CITY OF ALBUQUERQUE

September 20, 2022

Re: Restaurant Depot
1901 Menaul Blvd. NE
Traffic Circulation Layout
Engineer's Stamp 06-30-22 (H15-D039)

Based upon the information provided in your submittal received 09-13-22, the above referenced plan cannot be approved for Building Permit until the following comments are addressed:

C2.0

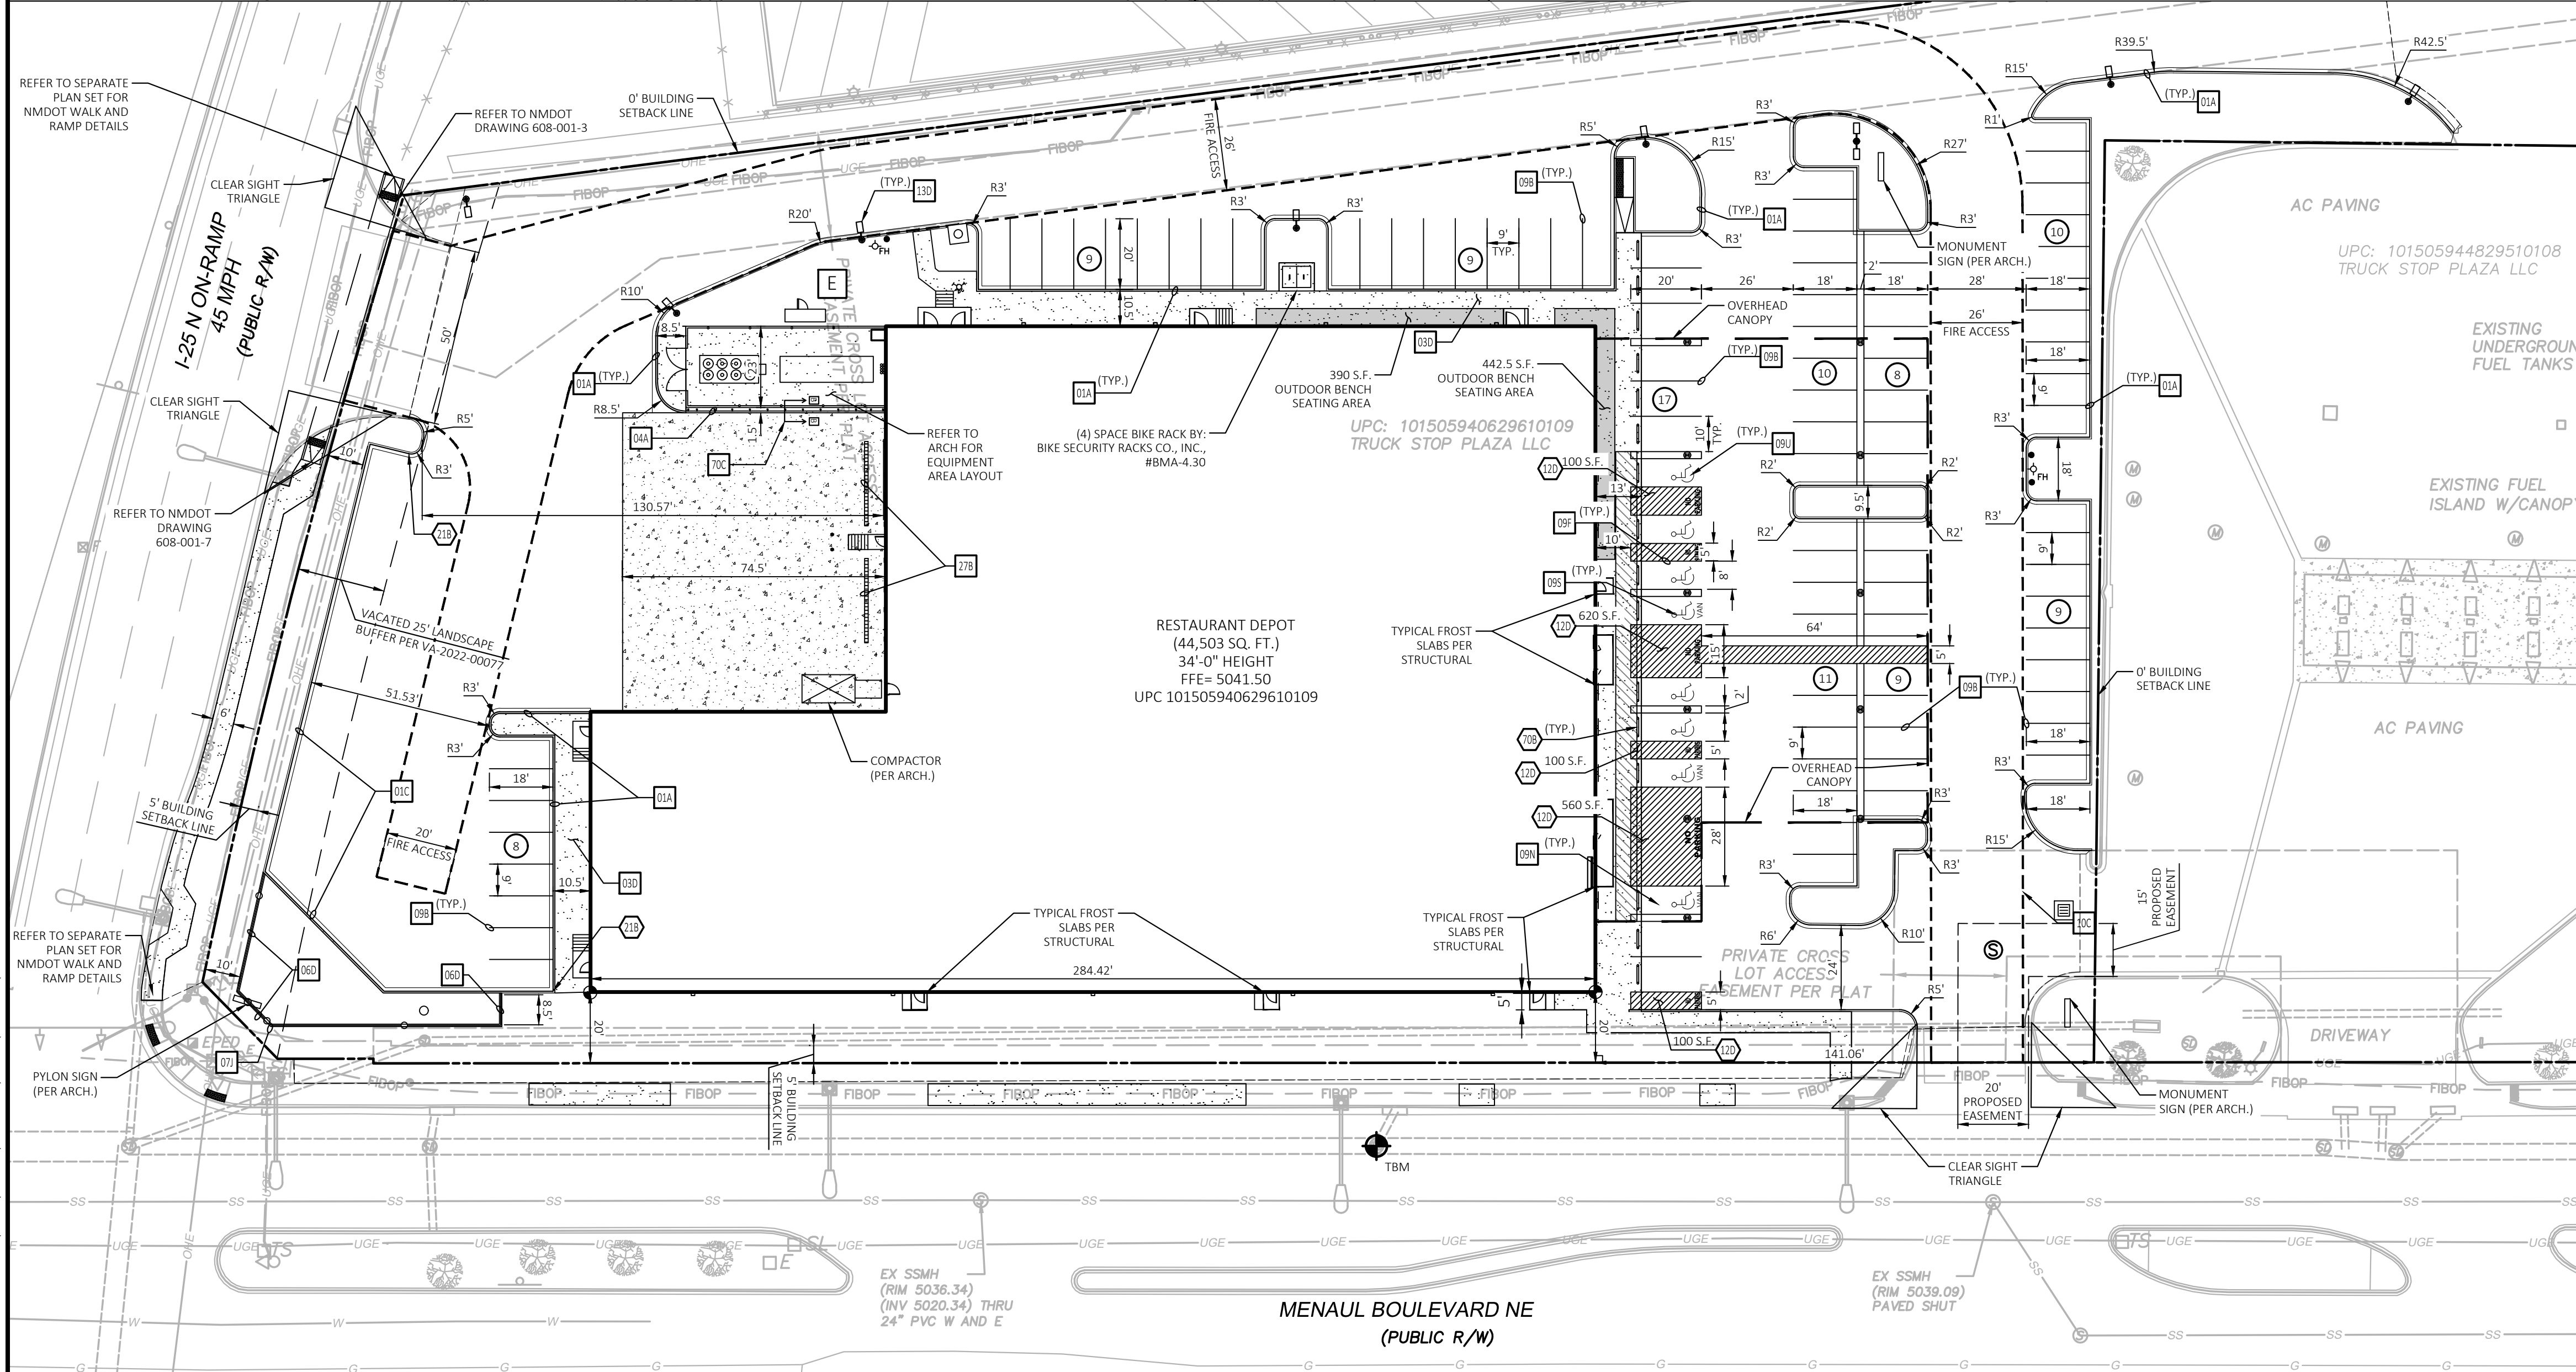
3. Identify the right of way width, medians, curb cuts, and street widths on Menaul Blvd, University Blvd, and on Pan American Frontage.
4. Clear sight triangle need to be provided at driveway access off University Blvd.

5. Show the bike Racks on the site plan.
6. Provide a copy of Solid Waste Approval and Fire Marshal Approval.
7. The ADA accessible parking sign must have the required language per 66-7-352.4C NMSA 1978 **"Violators Are Subject to a Fine and/or Towing."** Please call out detail and location of signs.

8. The ADA access aisles shall have the words **"NO PARKING"** in capital letters, each of which shall be at least one foot high and at least two inches wide, placed at the rear of the parking space so as to be close to where an adjacent vehicle's rear tire would be placed. (66-1-4.1.B NMSA 1978)

9. ADA curb ramps must be updated to current standards and have truncated domes installed.
10. Motorcycle parking spaces shall be designated by its own conspicuously posted upright sign, either free-standing or wall mounted per the zoning code.
